From: [REDACTED]
Sent: 15 September 2017 13:35
To: Planning
Subject: Change of use 51 Sea Lane Rustington

We object to the change of use for 51 Sea Lane Rustington from Class A1 to class A for the following reasons.

**APPENDIX ONE:
DRAWING SHOWING EXTERNAL EXTRACT AND VENTILATION EQUIPMENT PROPOSED**

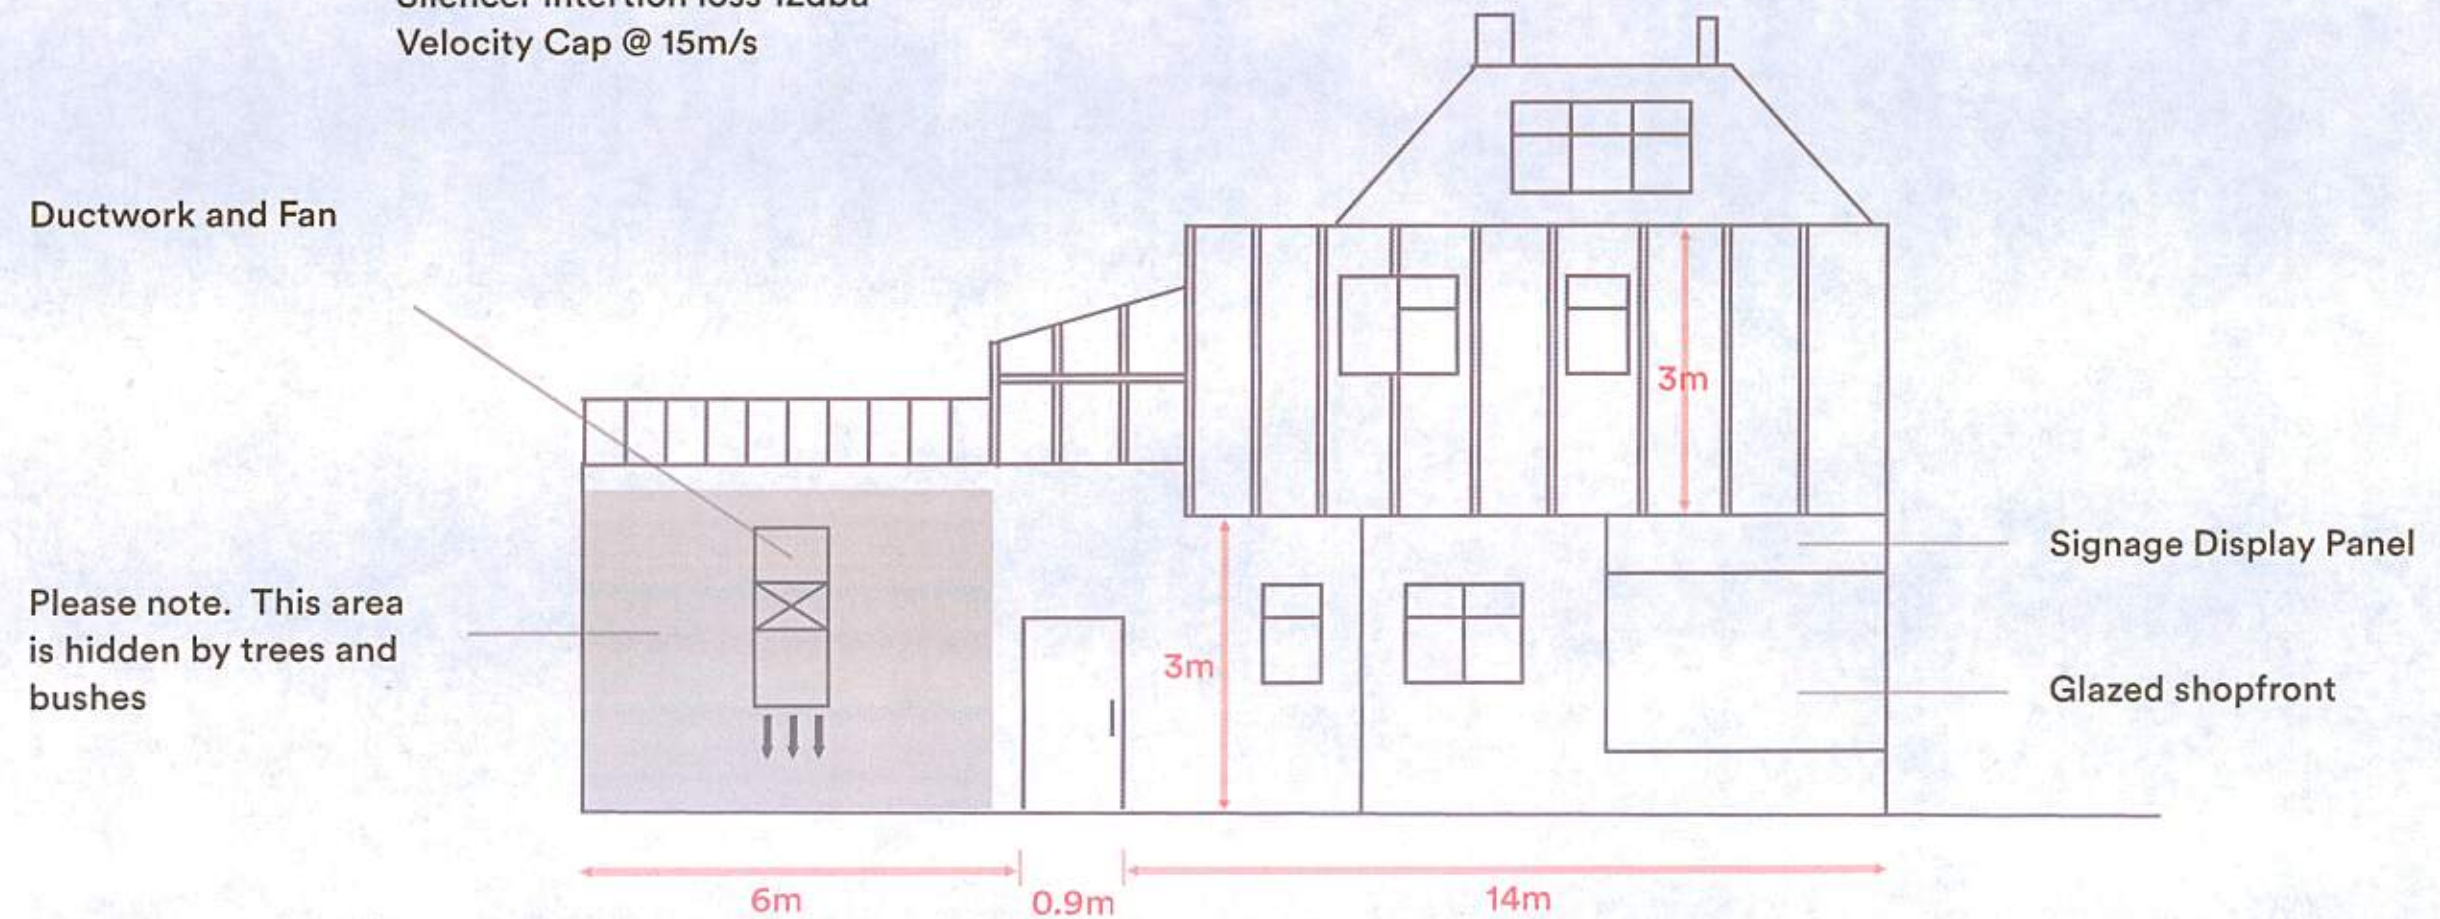
The position and use of a venting system for the kitchen which according to plans will be hidden by trees. This will be a potential fire risk especially as the house opposite are thatched roofs. The ventilation system would also produce noxious food odours and noise.

APPENDIX TWO:
DRAWING SHOWING PROPOSED REFUSE FACILITIES

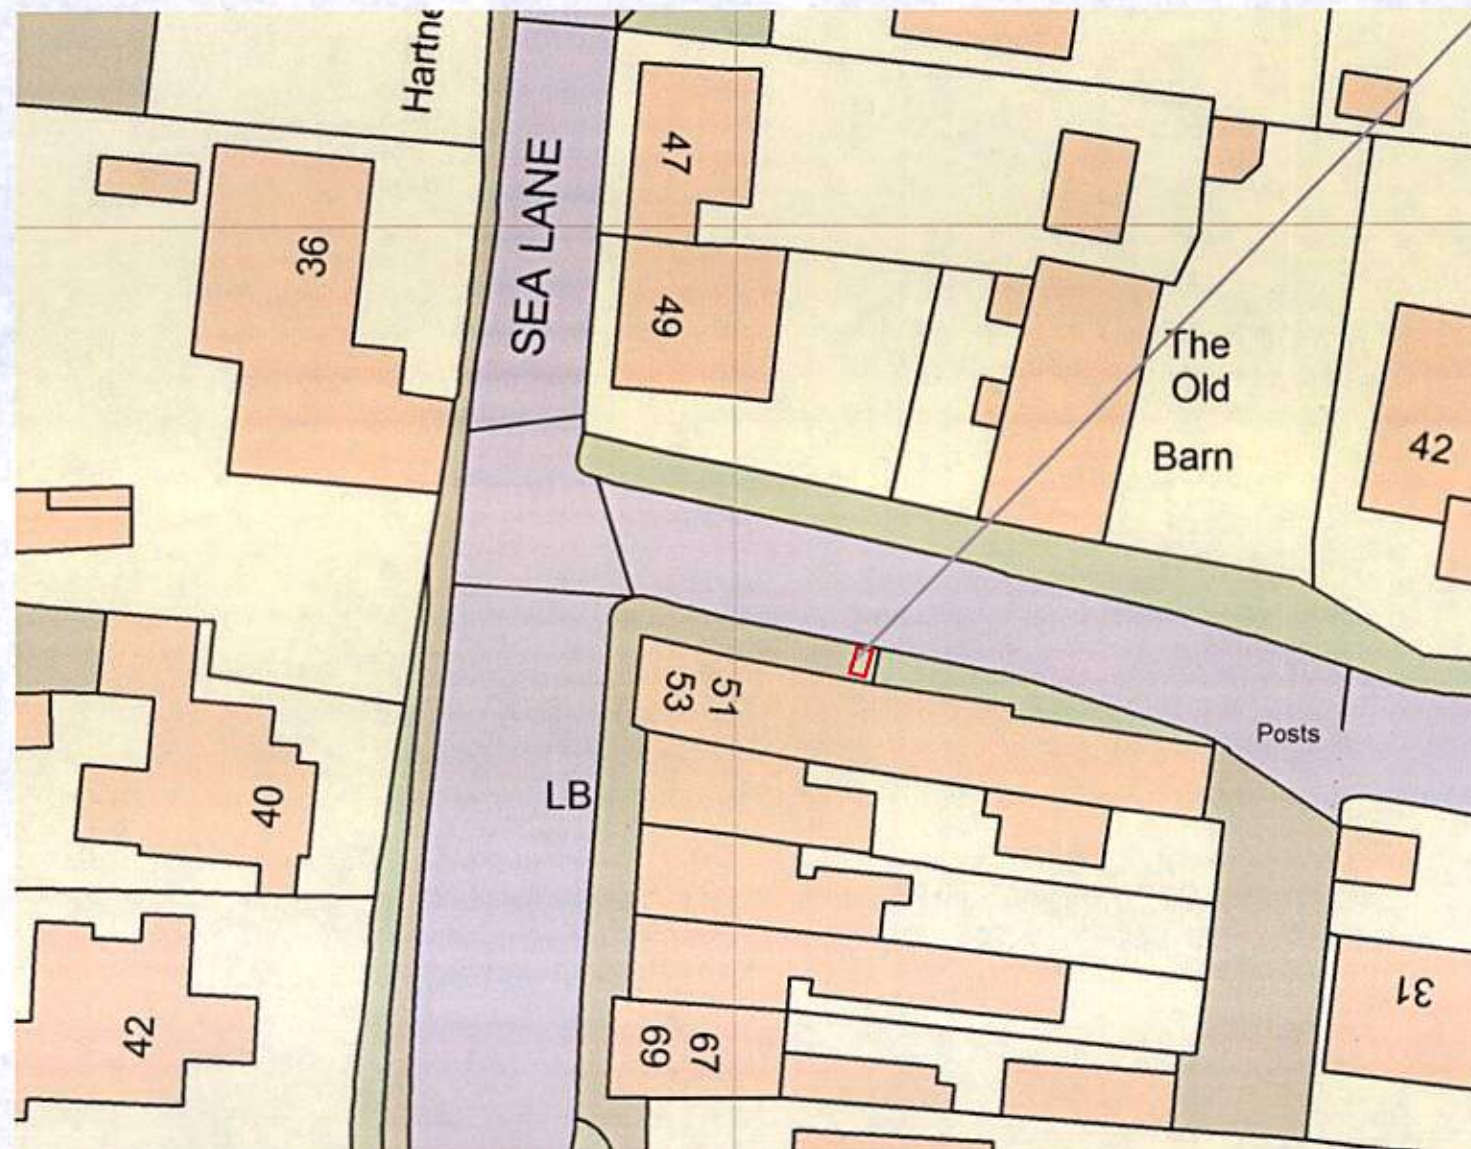
The potential for increase of rubbish that will attract foxes and vermin.
